## Review Comments (87)

## GALLOWAY RESPONSE TO COMMENTS

SHEET 3 OF 4

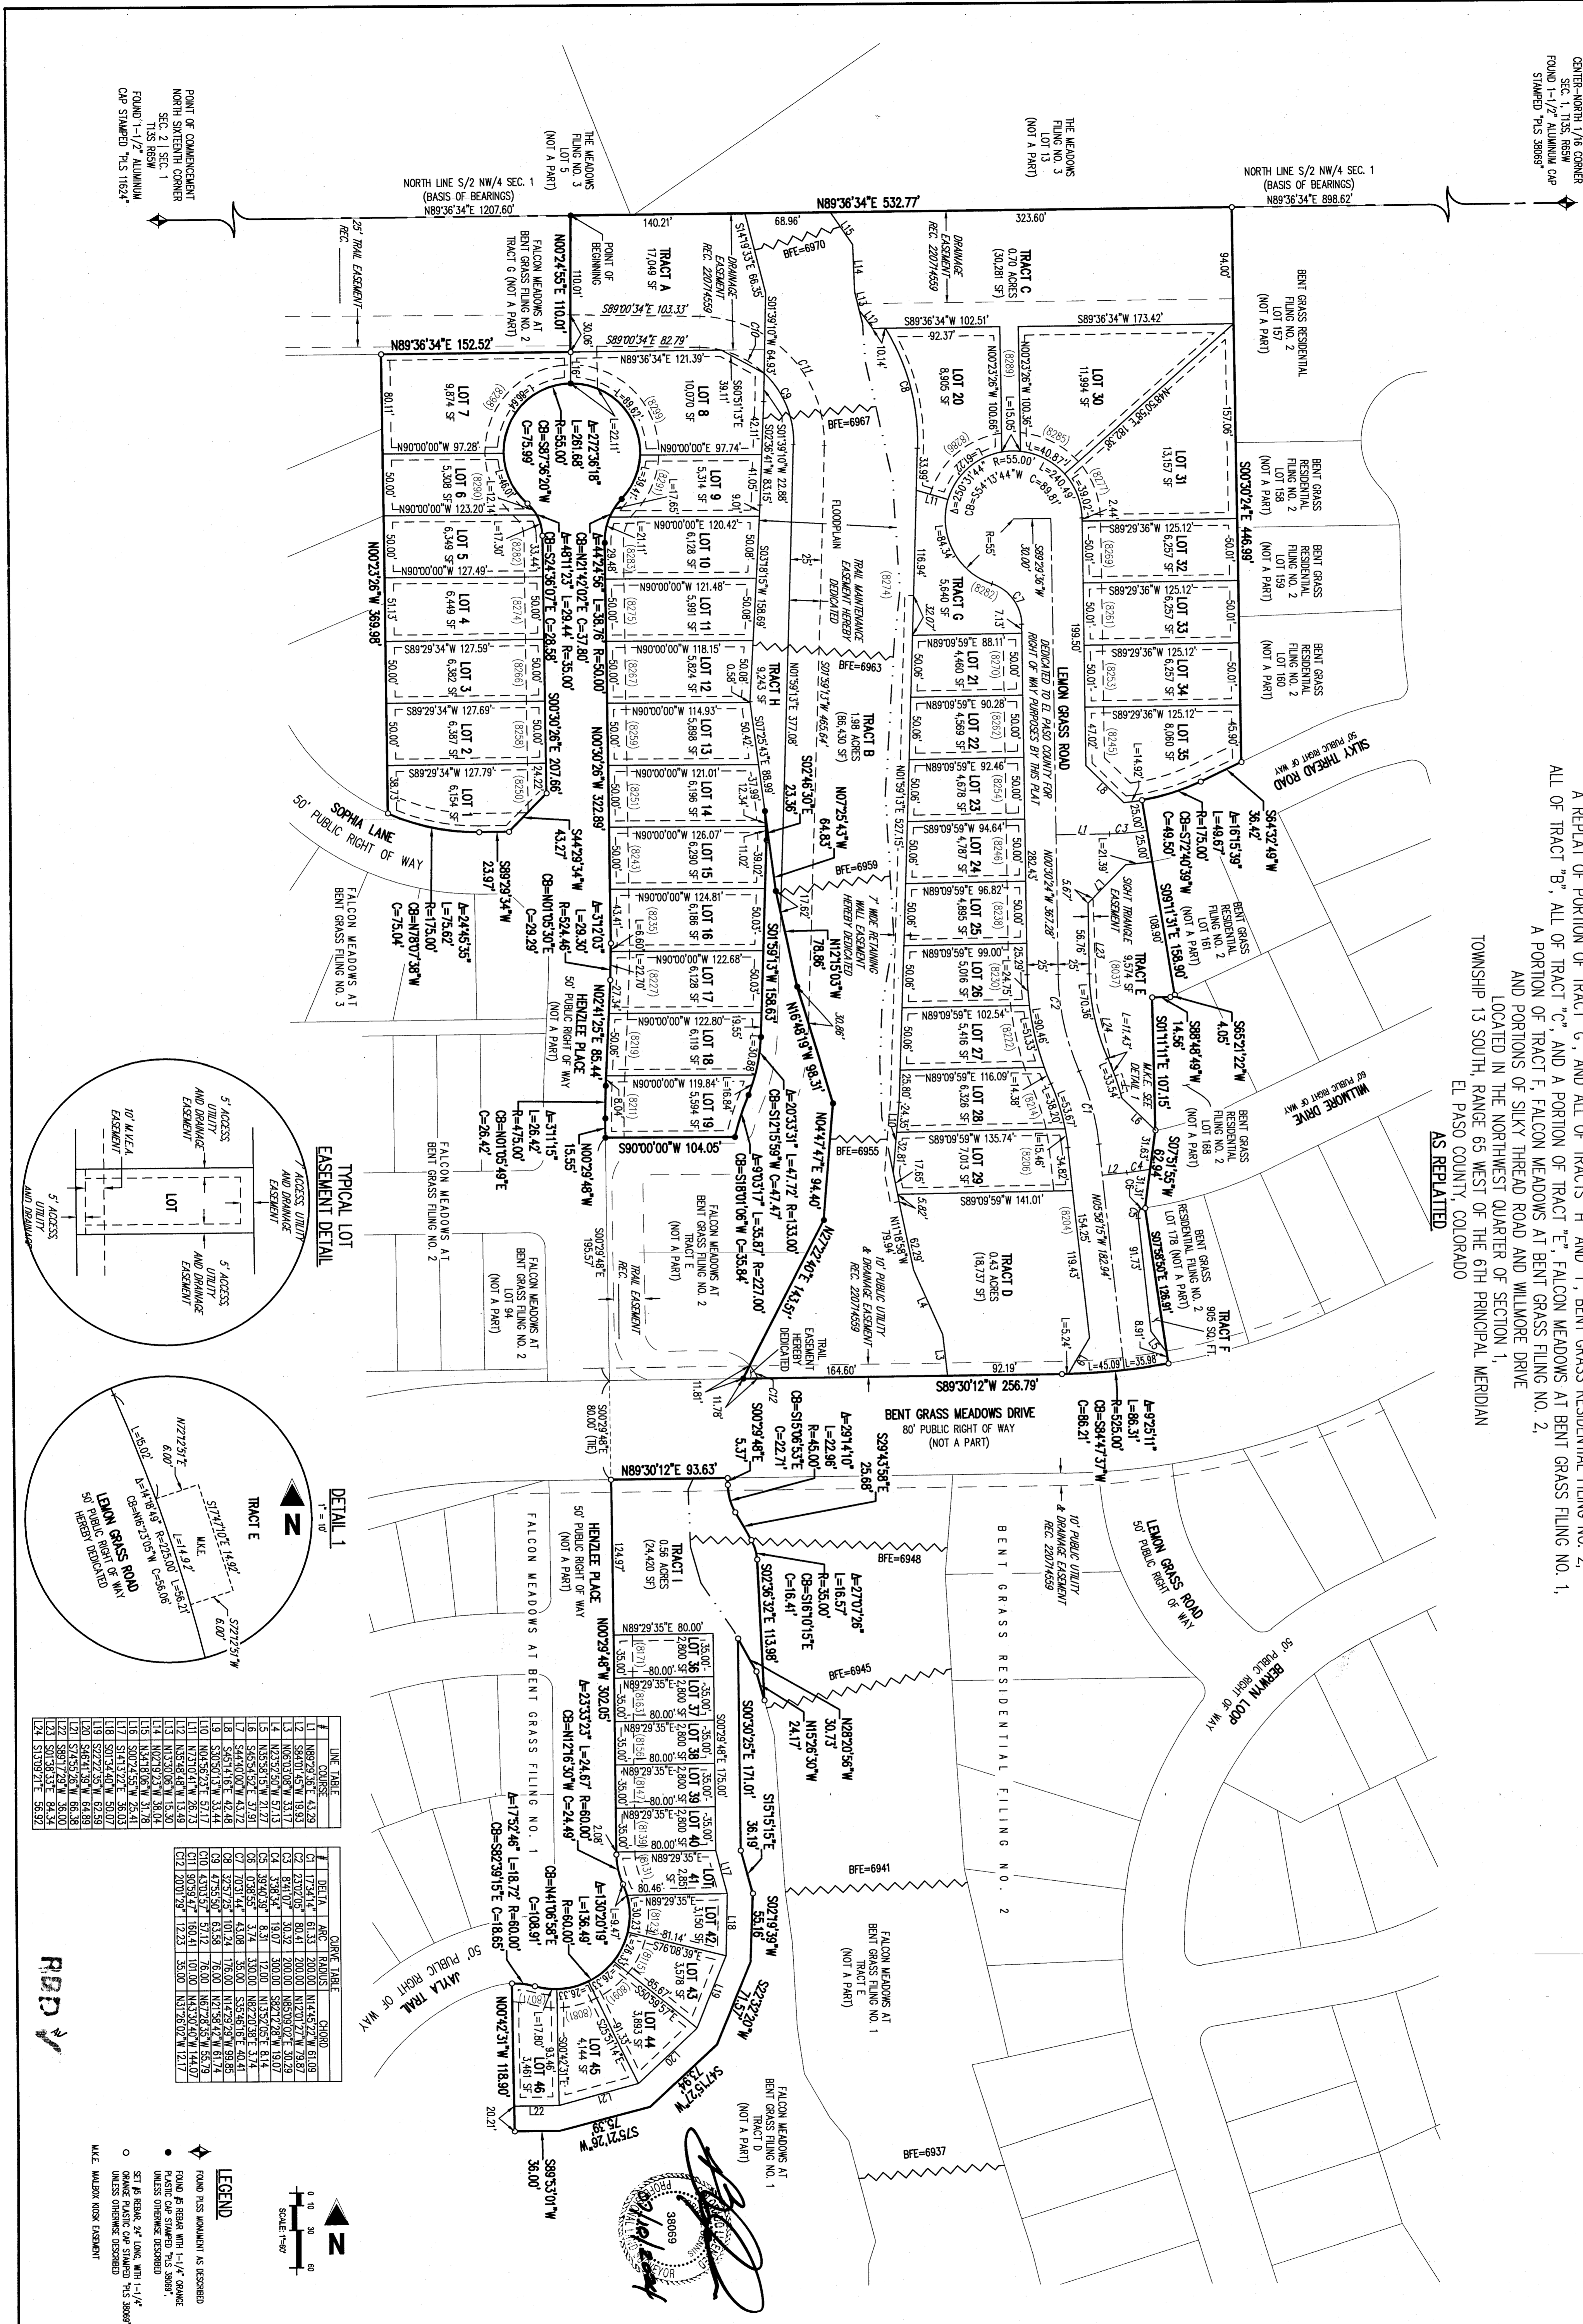
1. As stated in my last review lots 37-29 are addressed from Jayla Trail, now these lots are renumbered as lots 45-47. Lots 45-47 are addressed from Jayla Trail. Please add the street name Jayla Trail to the plat. You can gray it out, if does not need to be bold, since this street was a part of another filing. But it should be clear what street these lots are addressed from.

2. Lots add to this filing, 30-36, and an additional lot on Lemon Grass Road. Addressing will need to shift on this sheet from how it was originally assigned. There will be an additional readdressing fee applied at the time of the review of the mylar. Plat fee and readdressing fee due.

3. Are addresses needed for tracts A, B, H & I ? If so, place the addressing marker, (xxx) where you intend on using the address. Once new addressing is received, the addressing will need to be added to the plat.
